CITY OF PORTLAND, MAINE  
DEVELOPMENT REVIEW APPLICATION  
PLANNING DEPARTMENT PROCESSING FORM  
DRC Copy

2001-0066  
Application I. D. Number  
04/24/2001  
Application Date  
Whaleback Rd,  
Project Name/Description

RE: Whaleback Road, Peaks Island - 089-F-002 - IR-1 zone

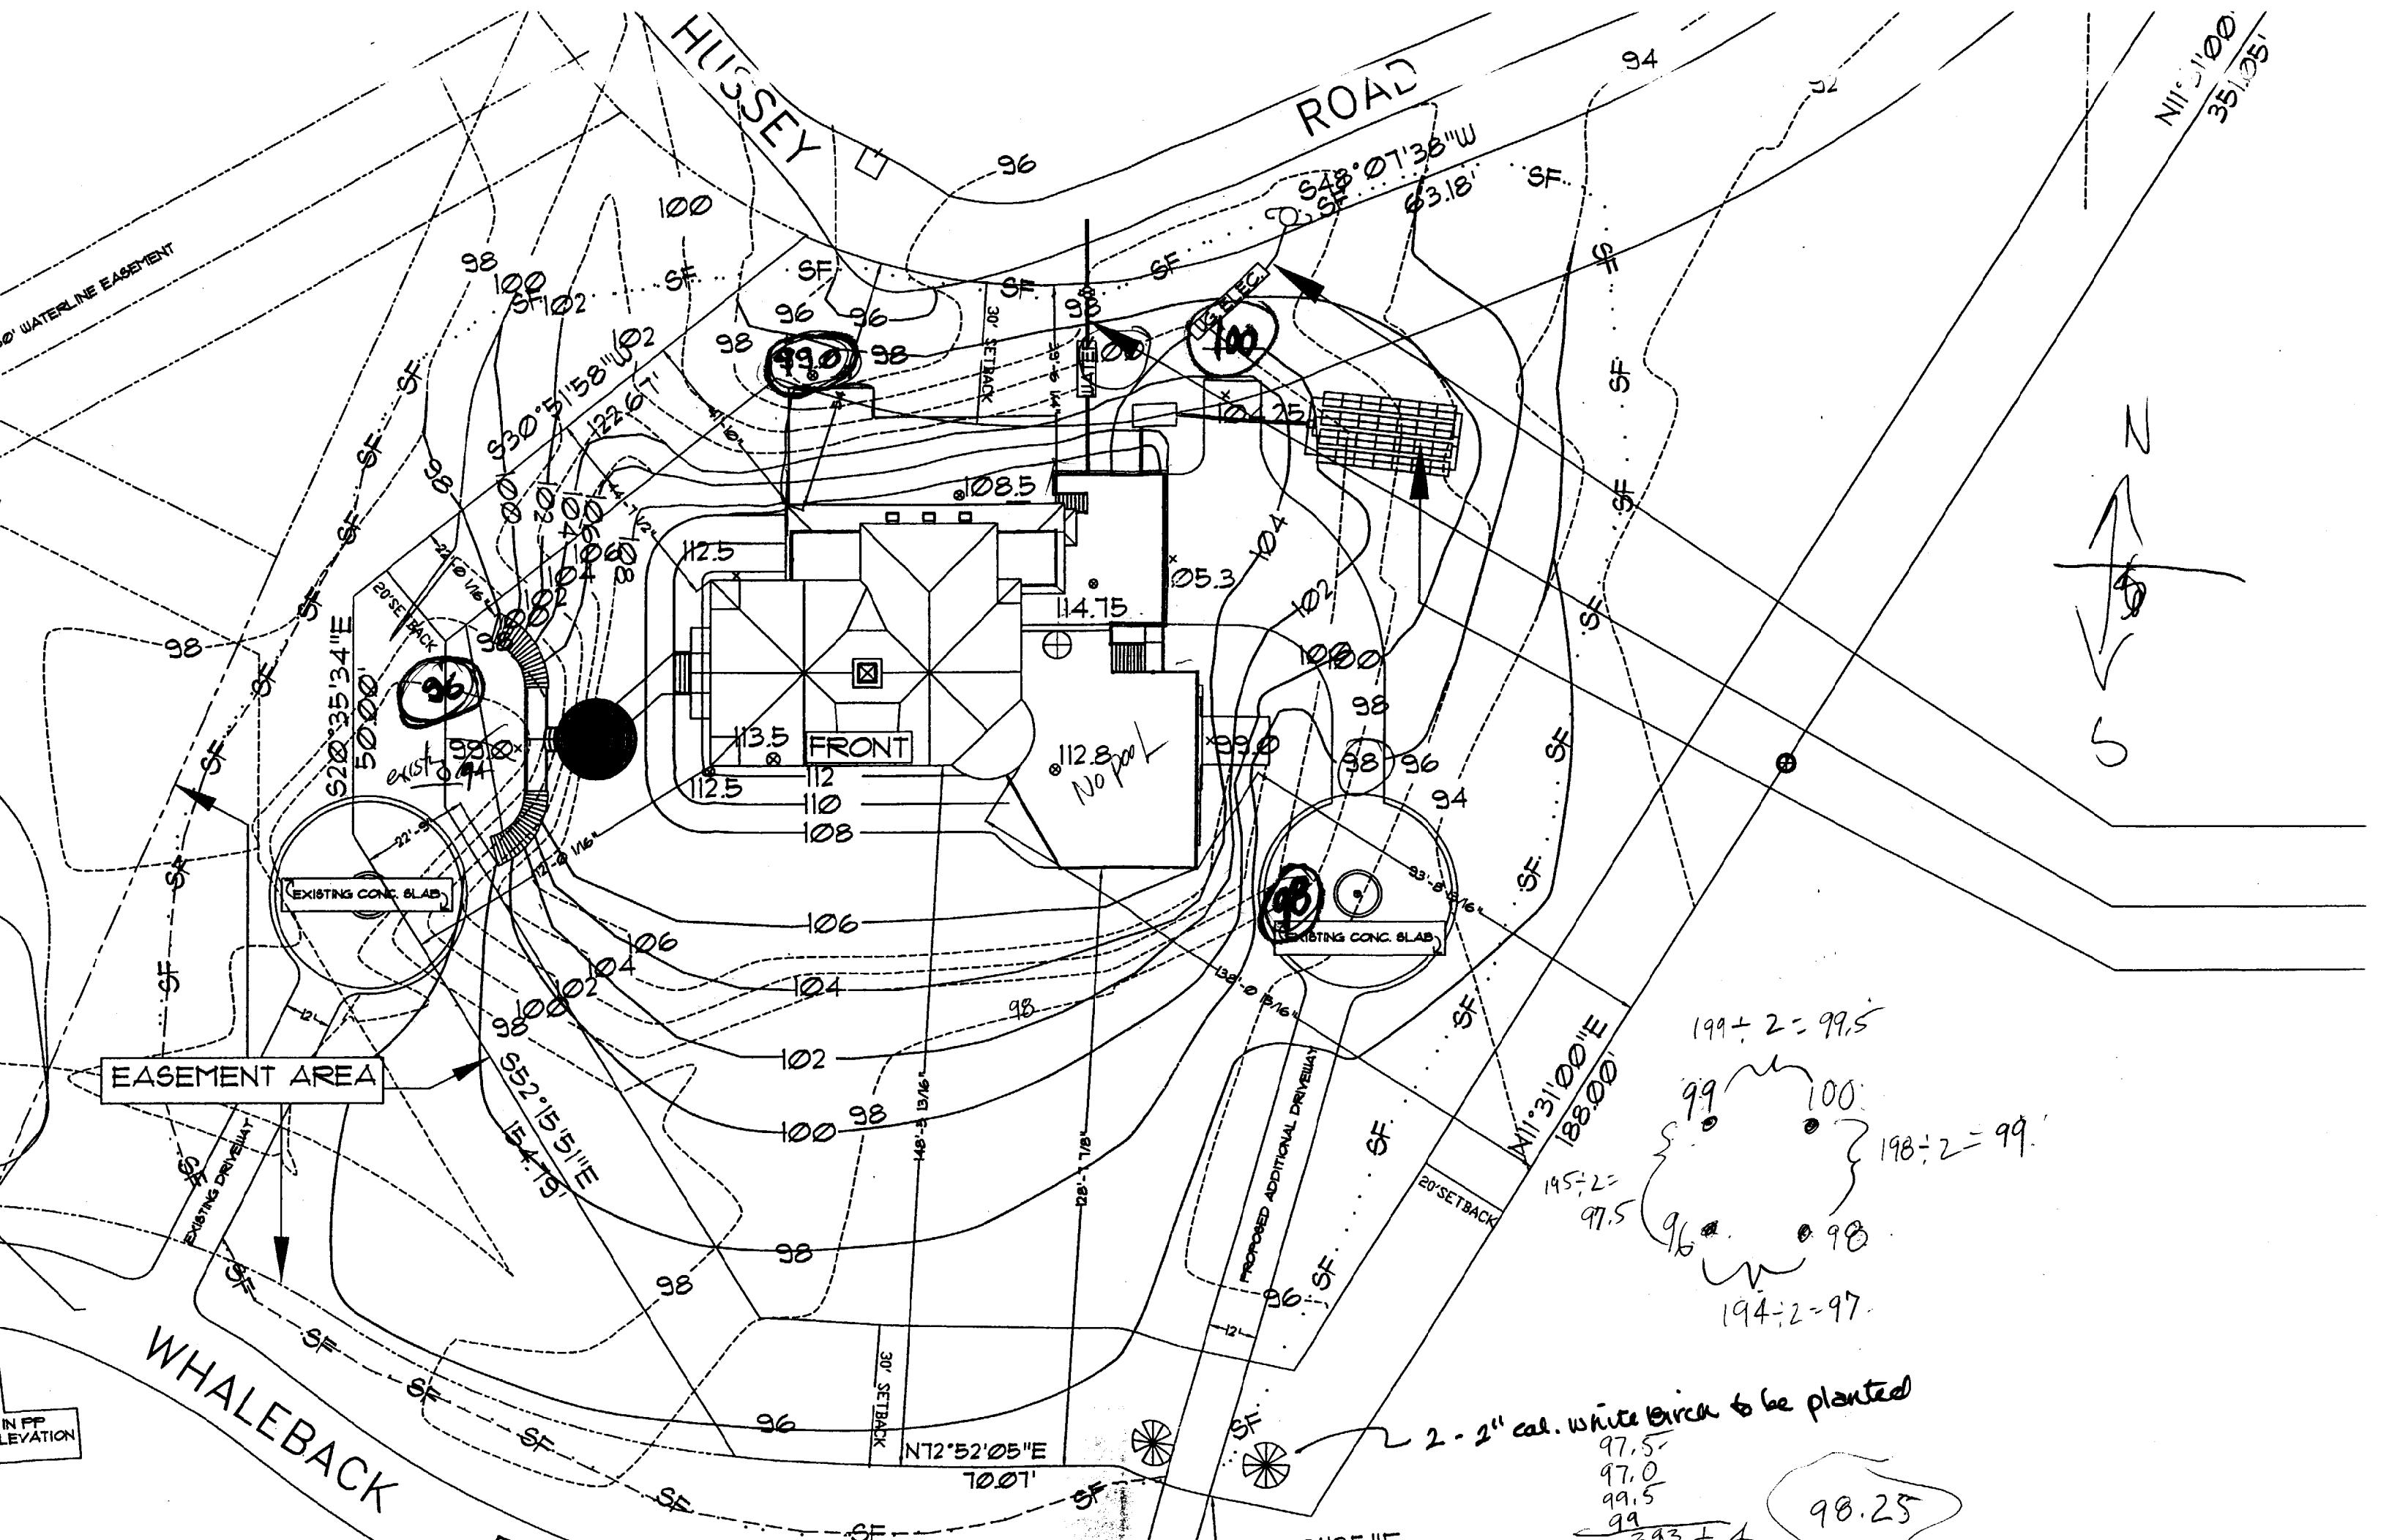
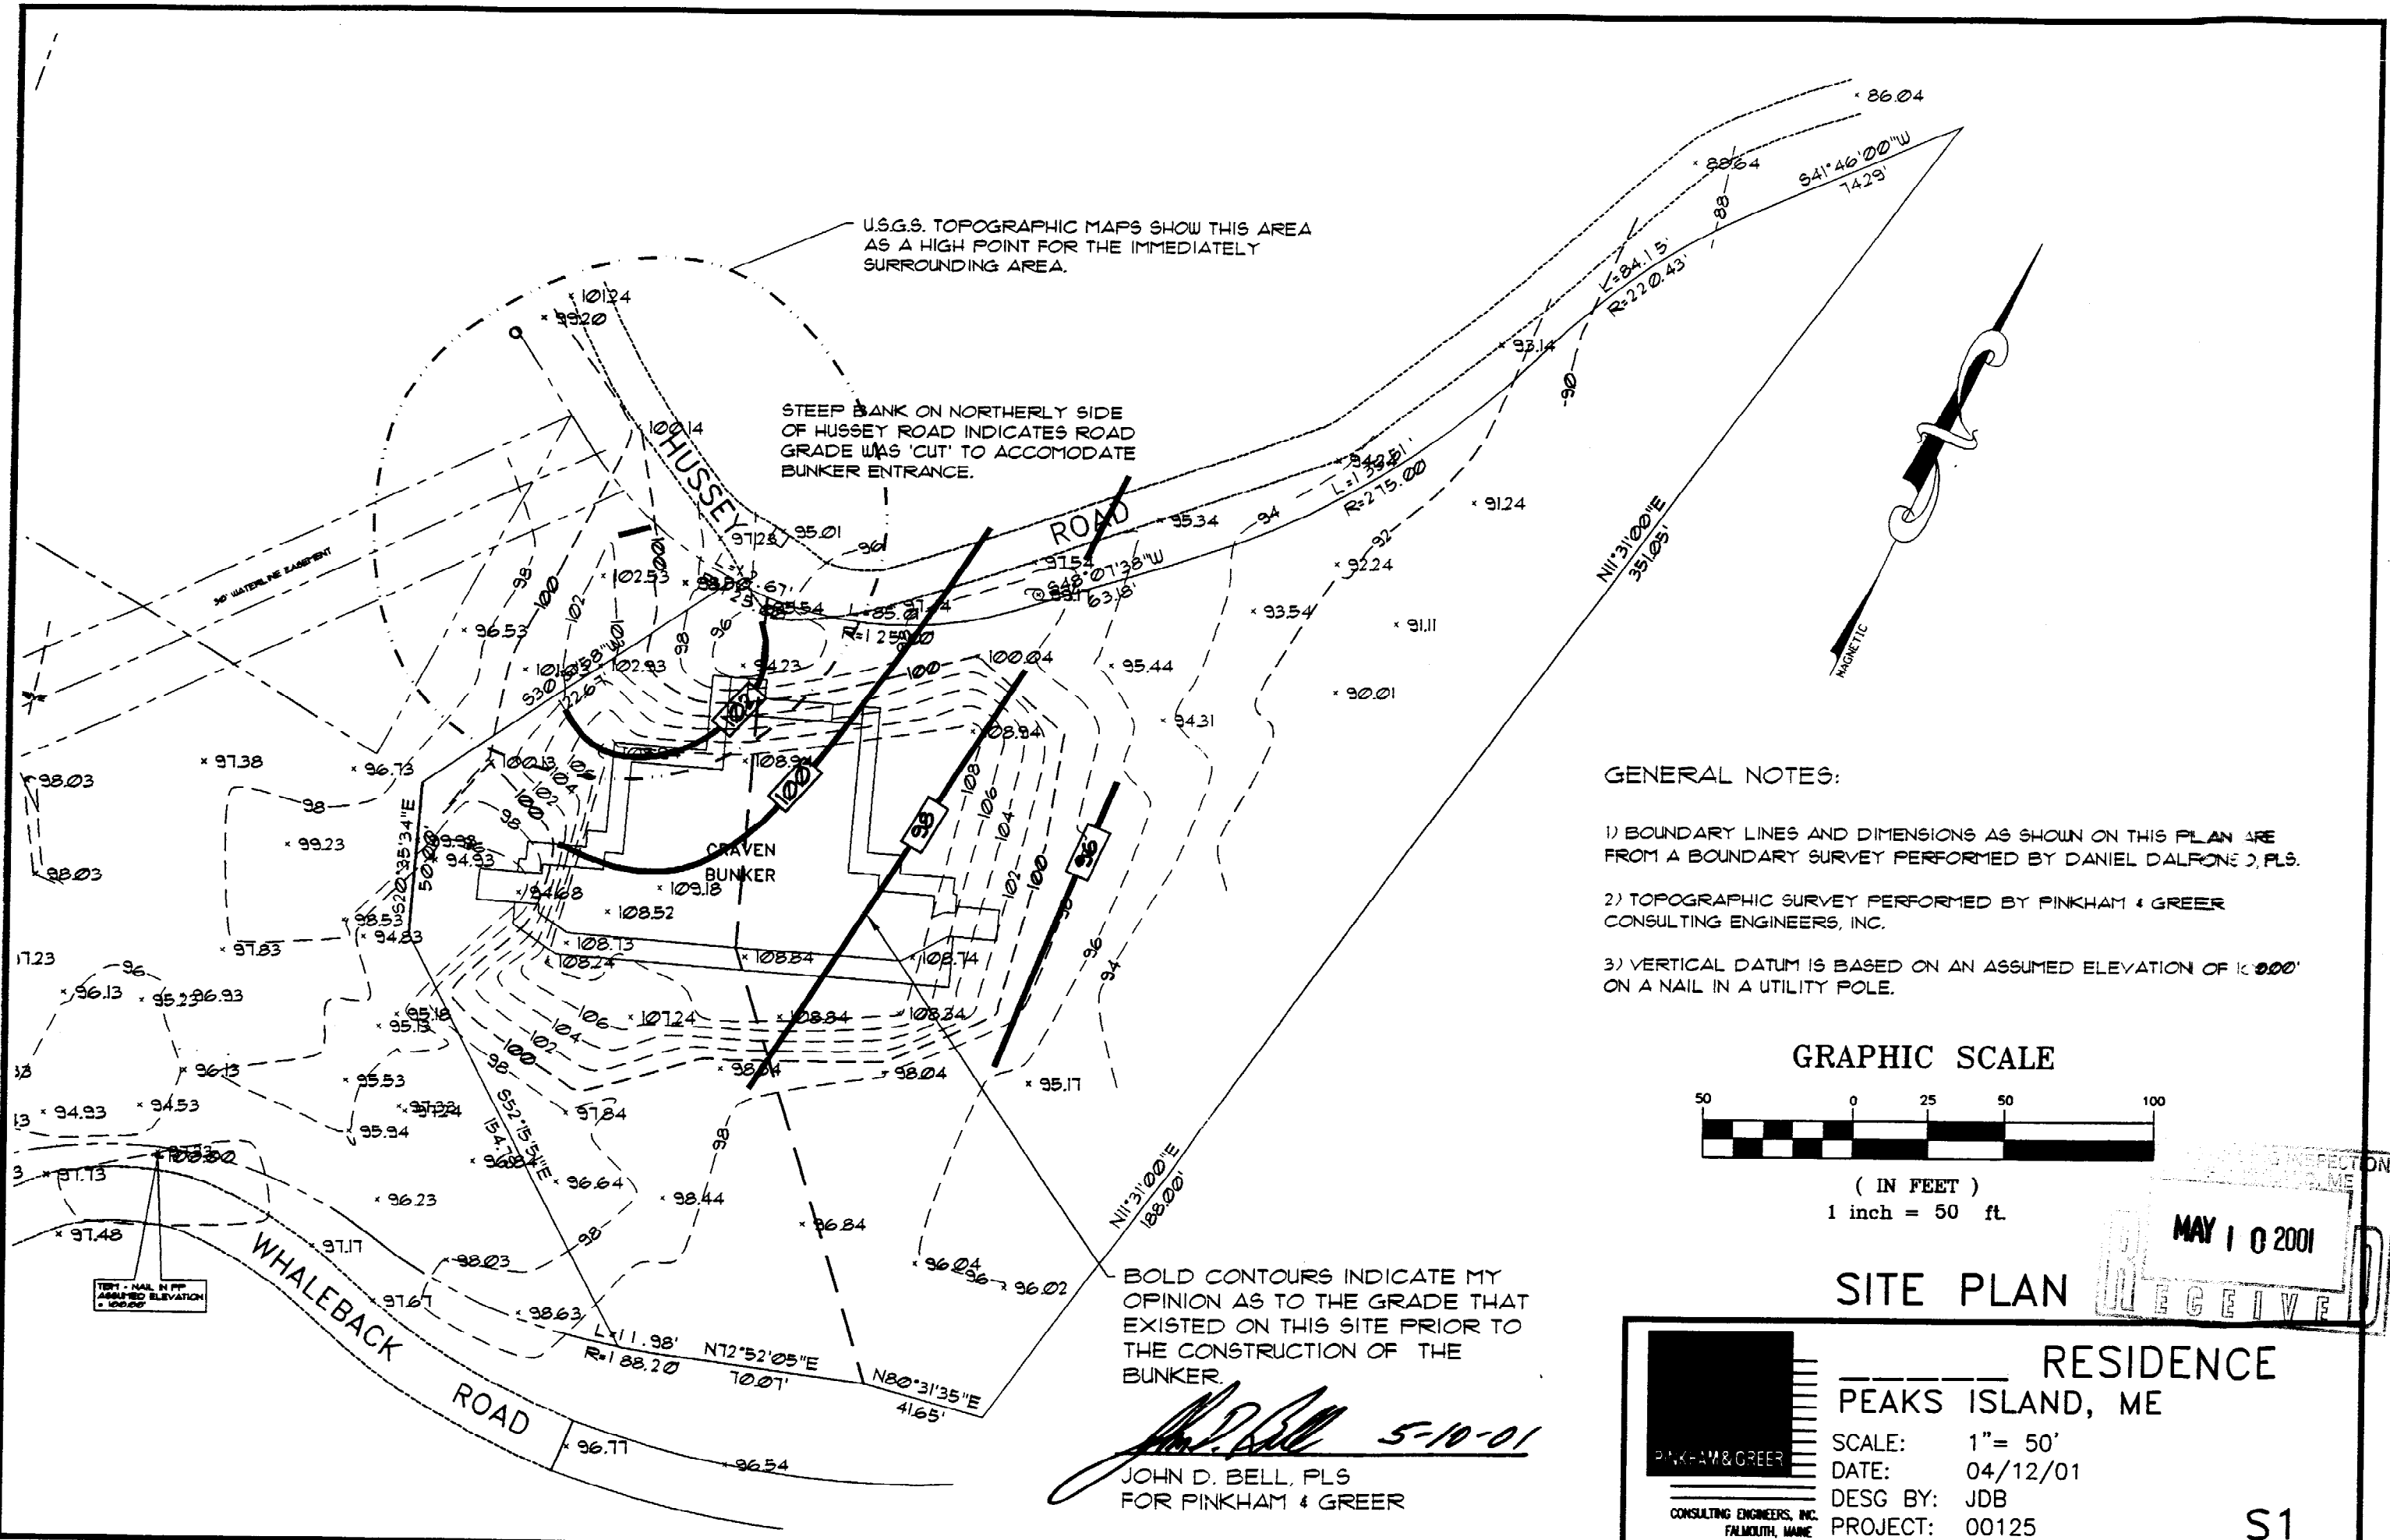
First, you are not meeting the maximum height requirement of 35 feet [section 14- 145.5(6)]. Your proposed height would be approximately 41 feet. I am basing that interpretation on the existing grade around the existing structure. I am considering the very elaborate, existing bunker a structure. I do not believe that it serves as just a foundation for this proposed single family dwelling. It is an actual bunker (Battery Craven) with internal walls and rooms. Although it is true that loam has been mounded up and around it for purposes of war- time concealment, I believe that it is a structure in itself. Therefore the entering grades around this concealed bunker, should more accurately be used for the grade base measurements than the roof of the bunker.

SITE PLAN IR-1 ZONE

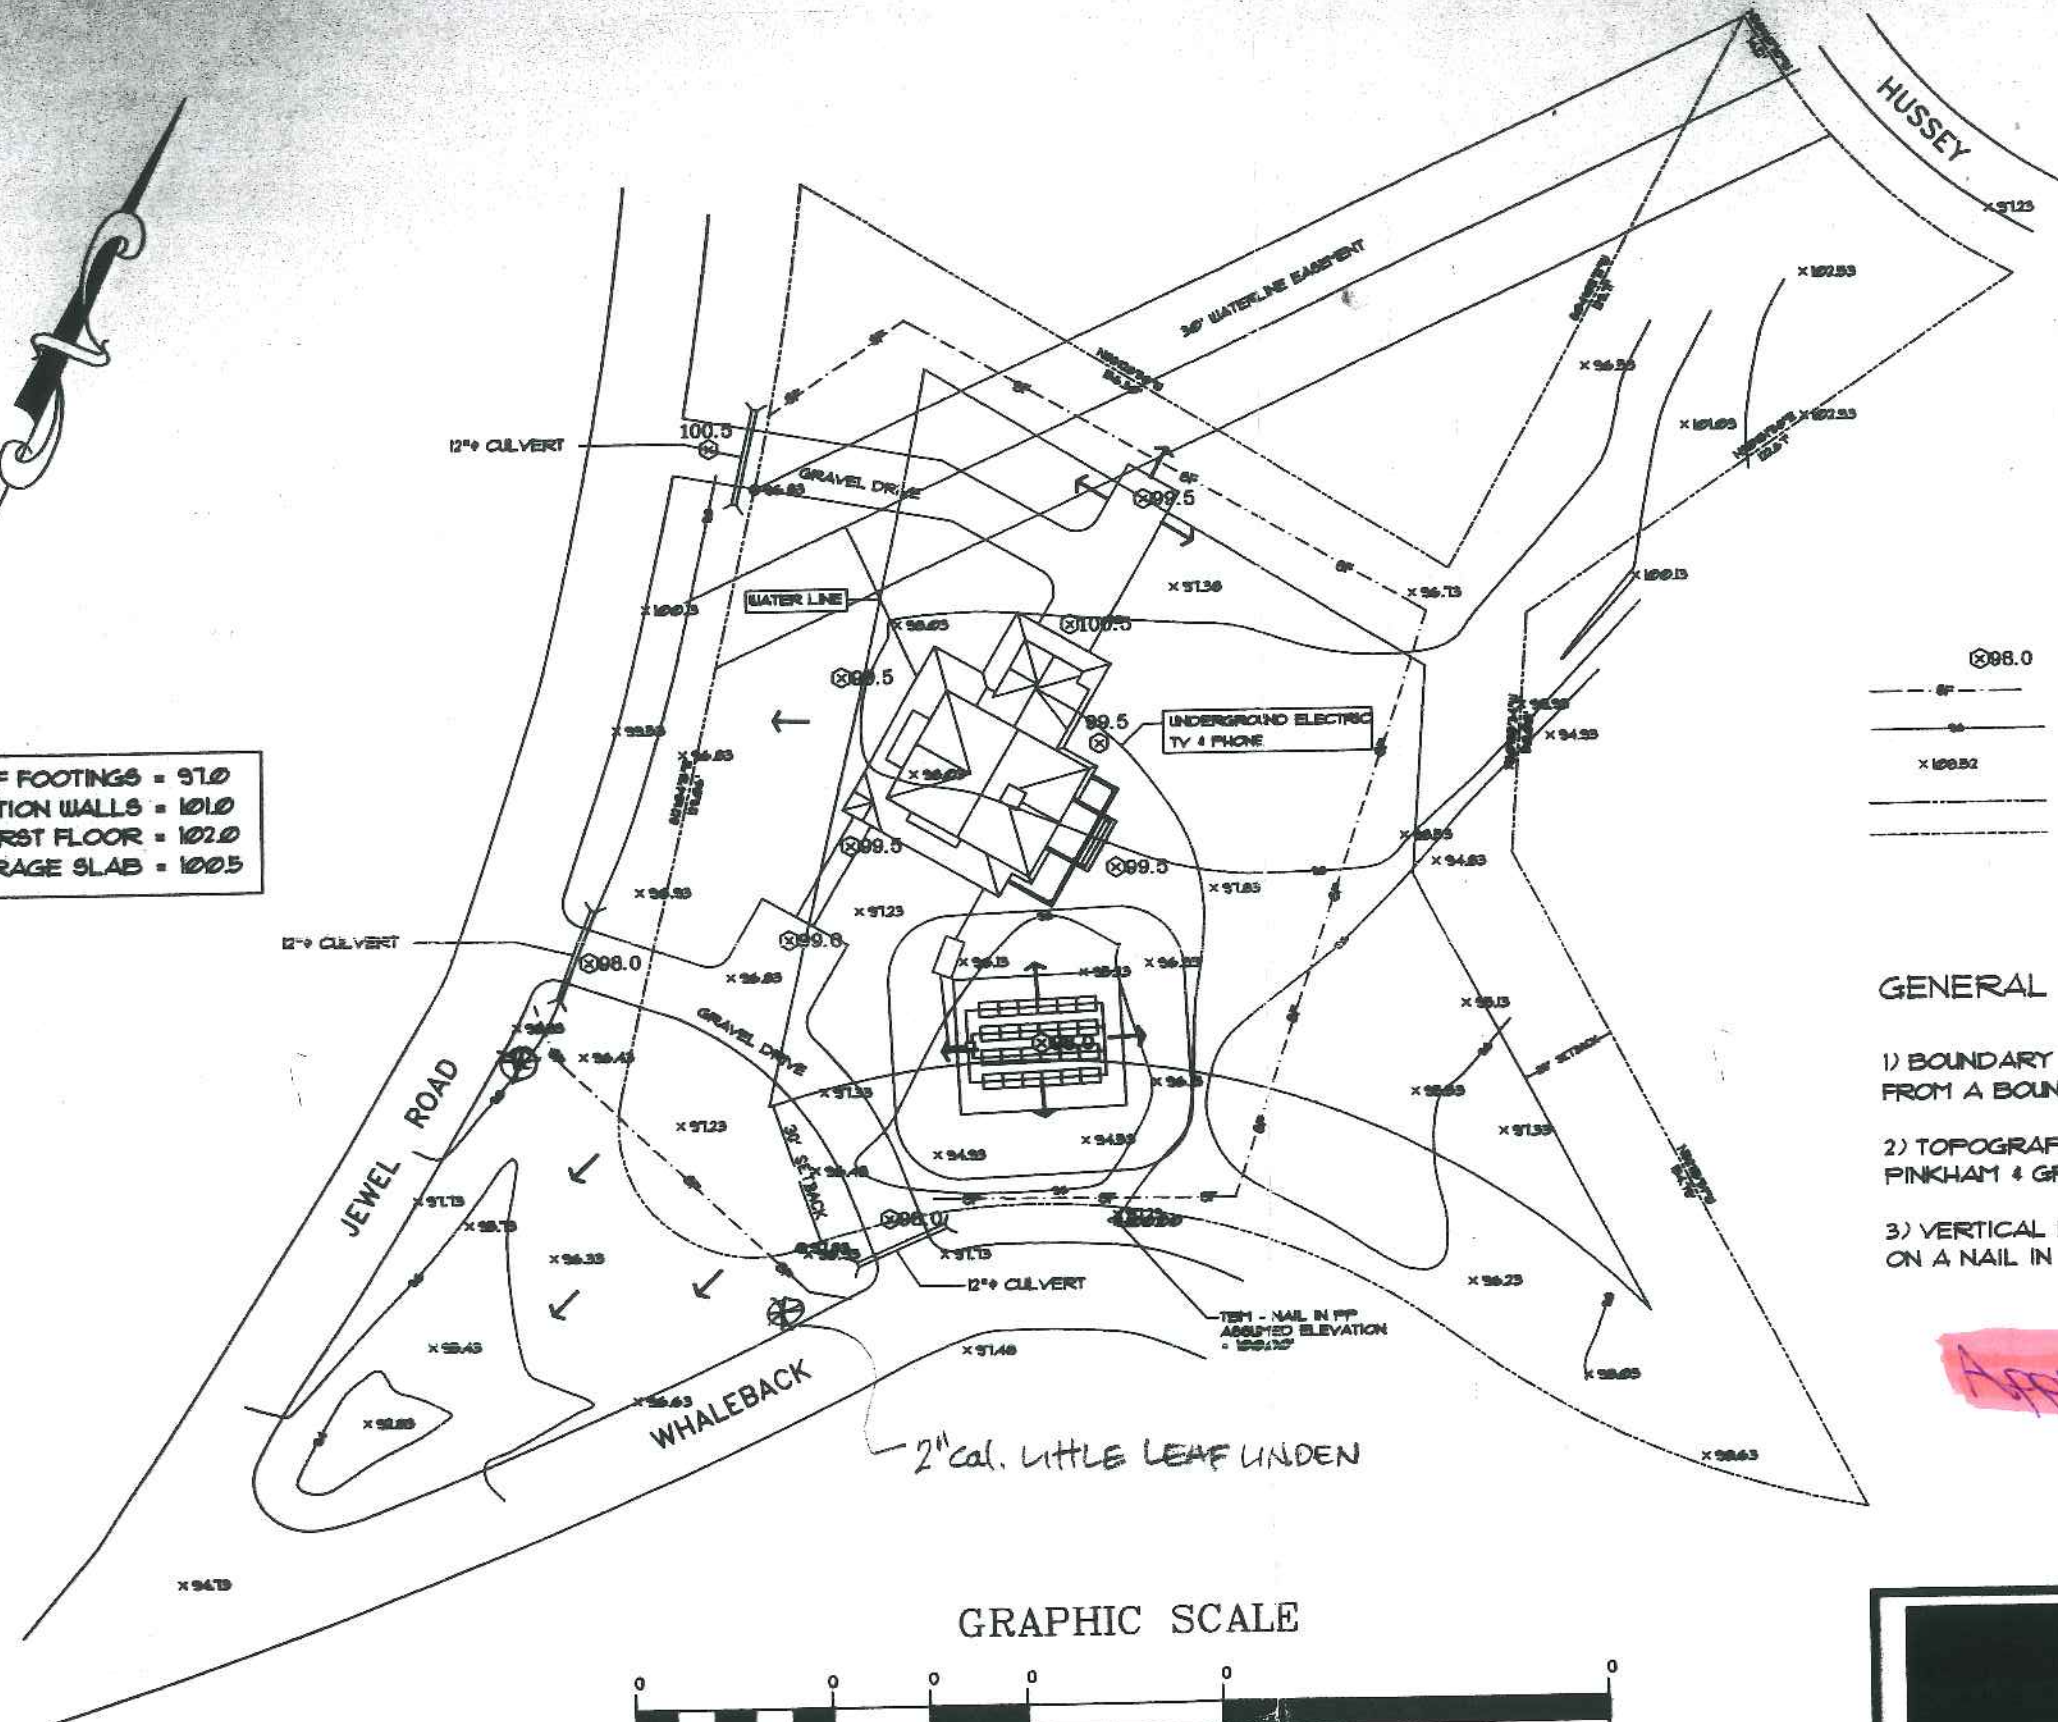
- 1 SIDESLOPES THAT EXCEED 3 TO 1 (33%) SHALL BE RIP-RAP OR APPROVED EQUAL
- 2 DRIVEWAYS MUST BE AT 12' WIDTH MINIMUM
- 3 All damage to sidewalk, curb, street, or public utilities shall be repaired to City of Portland standards prior to issuance of a Certificate of Occupancy.

- 9 The site contractor shall establish finish grades at the foundation, bulkhead and basement windows to be in conformance with the first floor elevation (FFE) and sill elevation (SE) set by the building contractor to provide for positive drainage away from entire footprint of building.
